Response to Planning Application

From: Arun District Council Leisure & Greenspace

Application ref: AL/143/24/RES

Description: Approval of reserved matters following outline consent AL/129/21/OUT for 95 No residential space (including play areas), infrastructure and works. This application is in CIL Zone 3 and is CIL Liable

Title: Play and Open Space Proposals Sheet 1

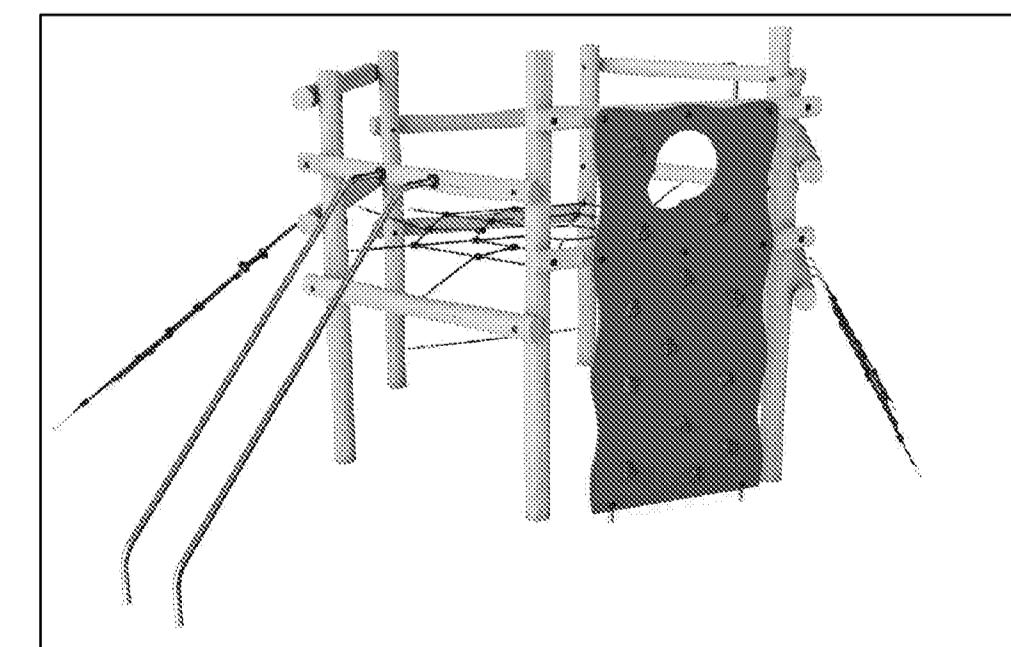
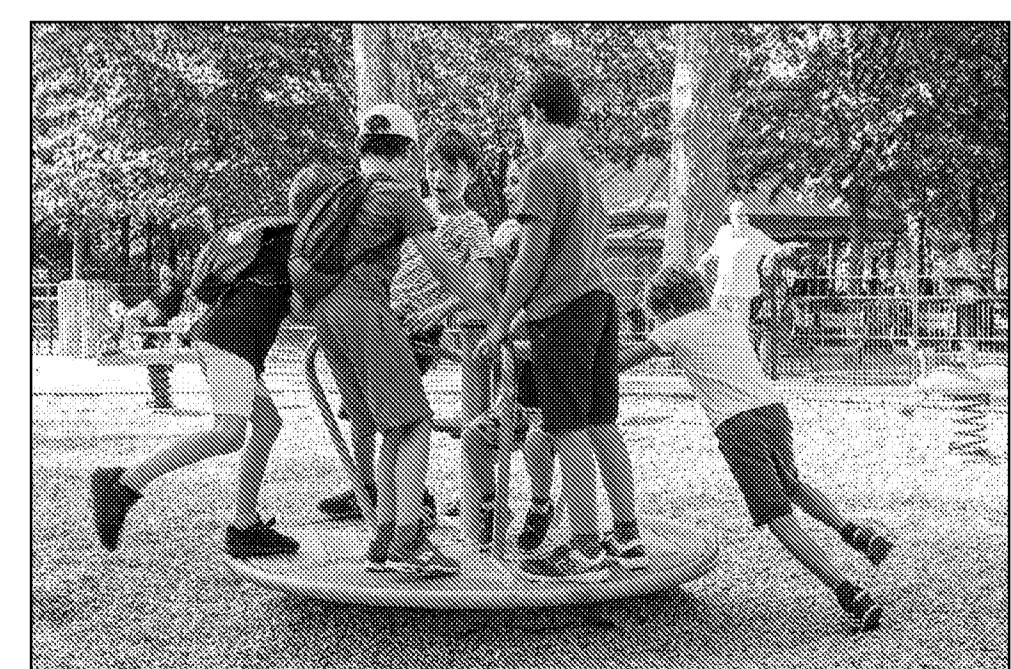
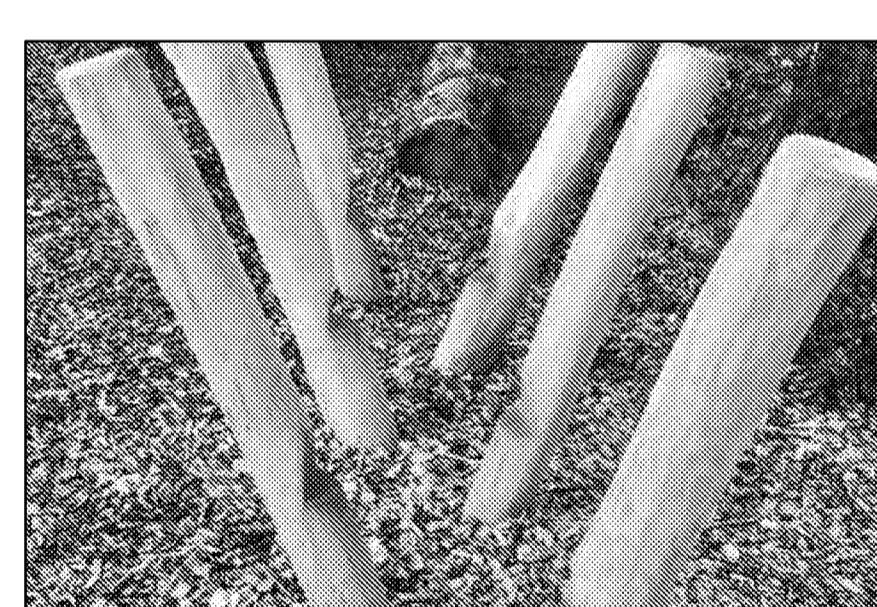
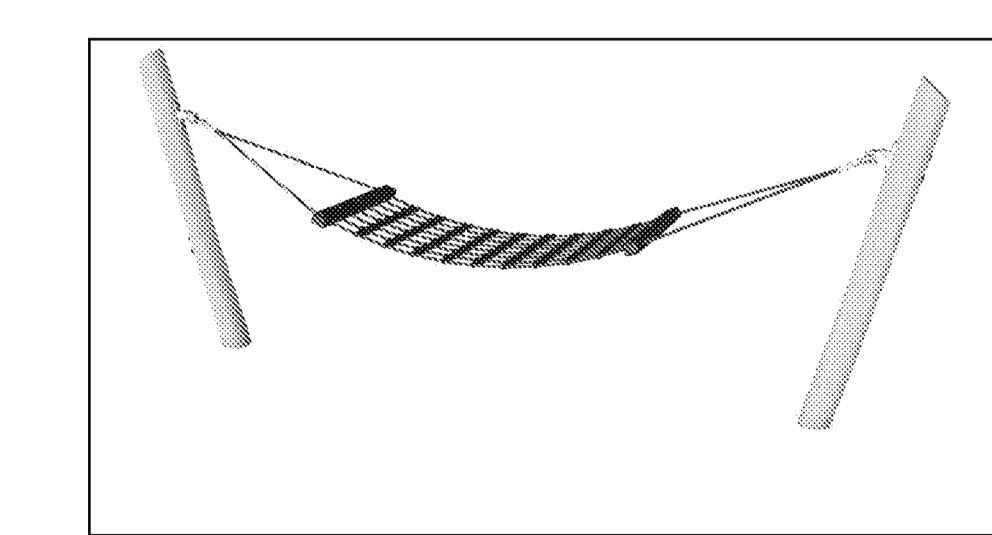
Play and Open Space Proposals Sheets 1-3 GLS-020170-PL-2001 REV A – **LEAP** - Play proposals fall below the standard that would be required and within our SPD and Design Guide requirements. The play offer needs to provide inclusive and accessible play, providing an exciting and challenging offer with a good variety of play experiences. The list of play items indicated within the GLS-020170-PL-2001 REV A – LEAP dwg falls short on provision and specification, with little variety of play experience, no theme, no inclusive or accessible items, no pathway connection to facilitate accessible play and low value choices. An element of bespoke inclusion with timber theme is to be encouraged without brightly coloured panels however the scheme presented would not be supported. The LEAP has no indicated containment, required because of proximity to the adjacent SuDS feature. Physical separation between the LEAP and SuDS area would be required. Seating and bins should be positioned together, cycle stands and signage incorporated. Self-binding gravel destination pathways are not supported, requiring all weather macadam pathways for these high trafficked routes. RoSPA certification required if play within 30m of SuDS features.
